**Your Ref:** OWPC14646  
**Our Ref:** FG/198/16/PL 29-11-2016  
**Please ask for:**  
Andrew Wood

Demolition of existing house with erection of 2 storey building comprising of 8No.  
residential 2 bedroom flats & associated external works  
1 Sea Drive Ferring

Thank you for your internet representation made on 21st July 2017 which has been recorded as '**an objection**' with the comments as follows:

JOB: 1 SEA DRIVE, FERRING, WORTHING BN12 5HD
DWG: PROPOSED SITE PLAN

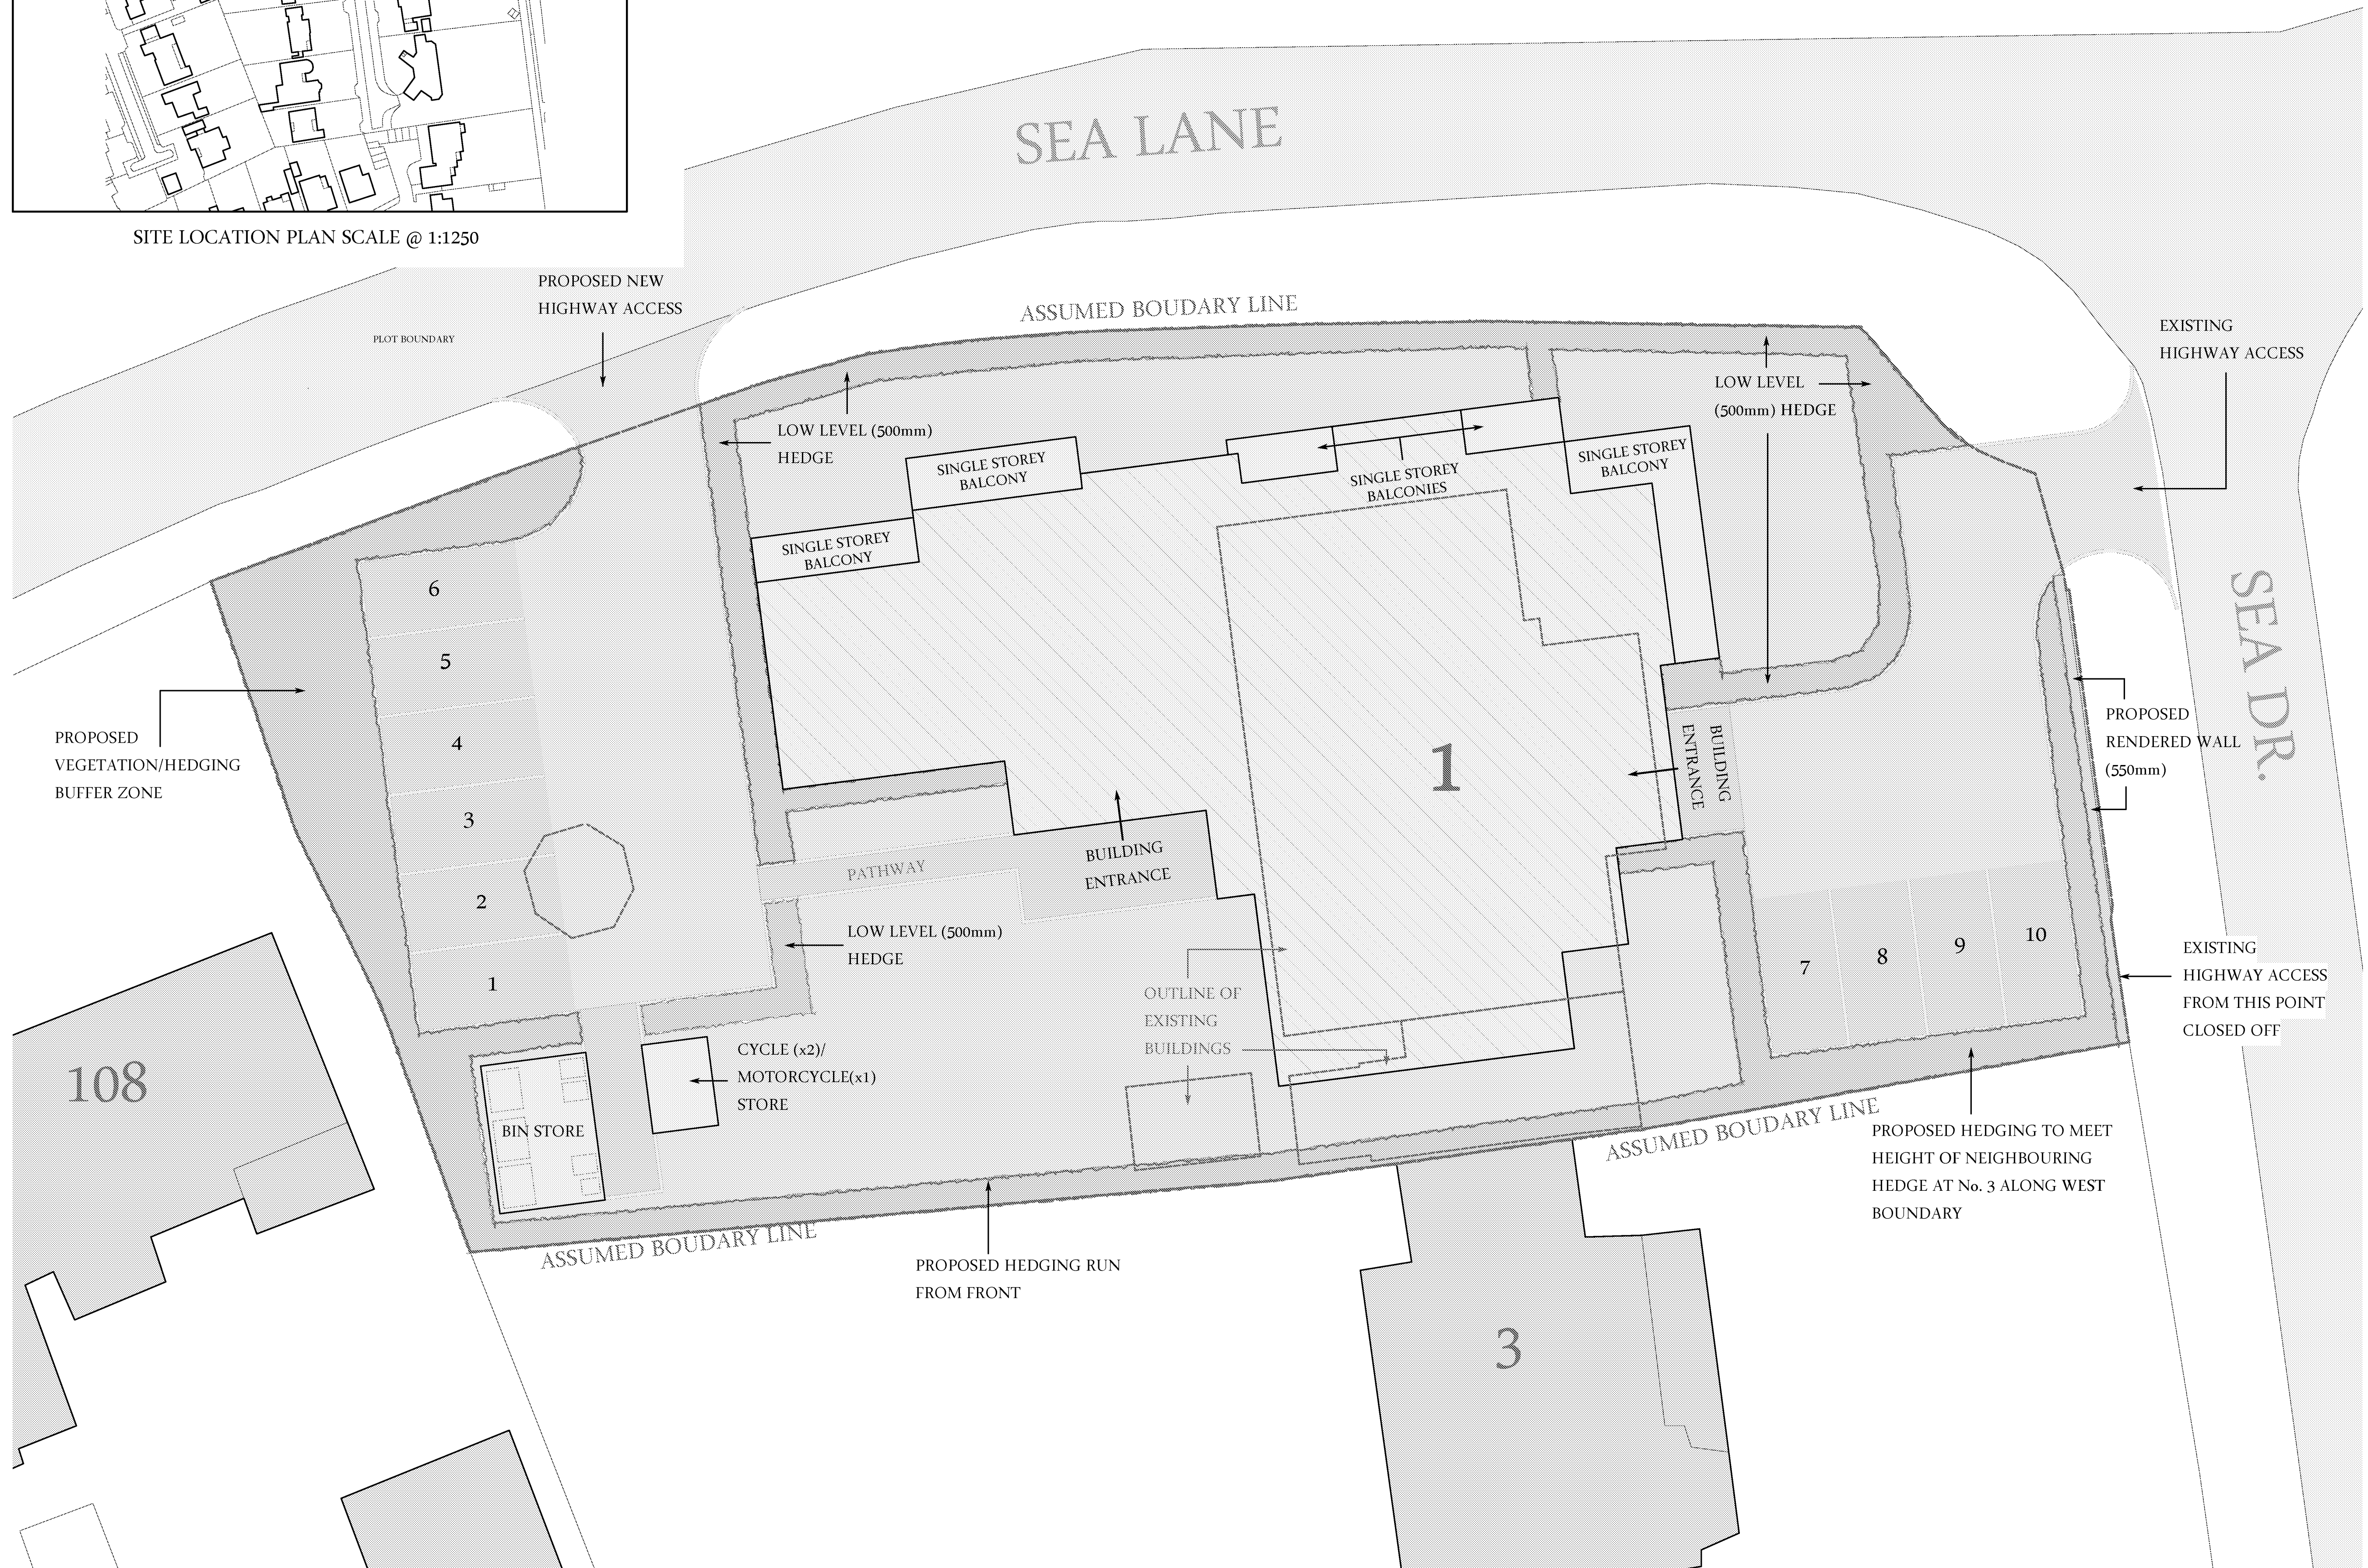
*The most recent amendments to these plans seem to centre providing the required number of parking spaces by reducing the size of each space. This clearly will make many of the spaces unusable due to lack of space to steer into spaces and/or open the vehicle doors. Intended residents will opt not to use the parking area and leave vehicles parked on the sea front.*
